COUNTY COUNCIL'S RESPONSE TO CONSULTATION ON THE FOLLOWING DEVELOPMENT PROPOSAL

Application No: 18/00513/REM

Proposal: Reserved matters to 10/01642/OUT - Village Centre (North) comprising retail units, B1 Use, 30 residential units, involving the erection of two, three storey buildings, partial demolition and change of use of Building 100 to provide B1 Use and demolition of buildings 101 and 102, plus the formation of vehicle parking and associated landscaping works.

Transport Schedule

3.8 Bus & Cycle Provision

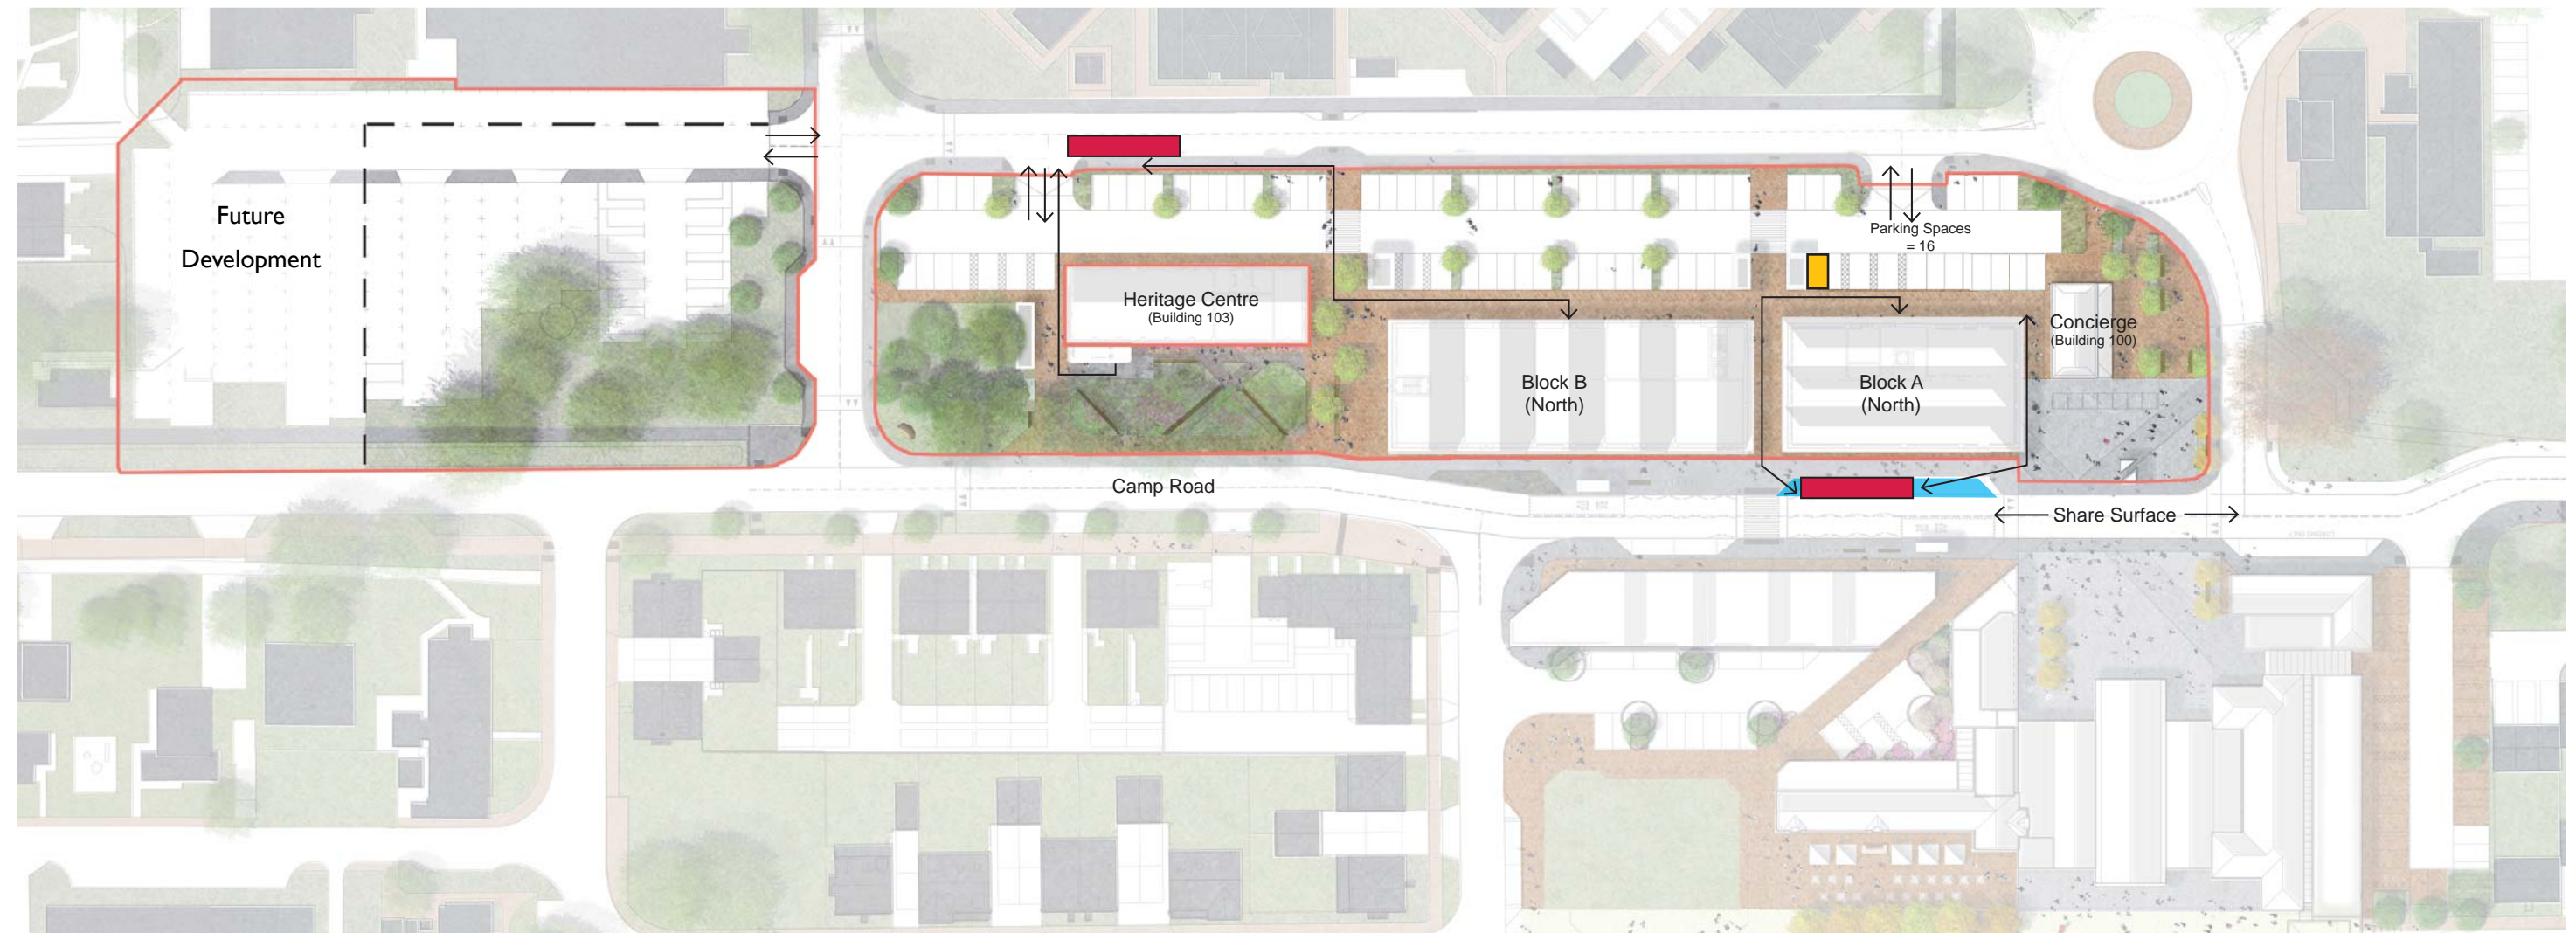
Sections 5.3.6 and 5.3.7 of the design and Access Statement present proposed provisions for bus and cycles and delivery and refuse collection respectively. These are acceptable in principle. However, they do not appear on the Proposed Site Layout plan No.CRD-00-ZZ-Dr-A-00901 and the Proposed Western Car Park Layout plan No.CRD-00-ZZ-DR-A-0910. Details of these proposed provisions must be submitted in discharge of conditions.
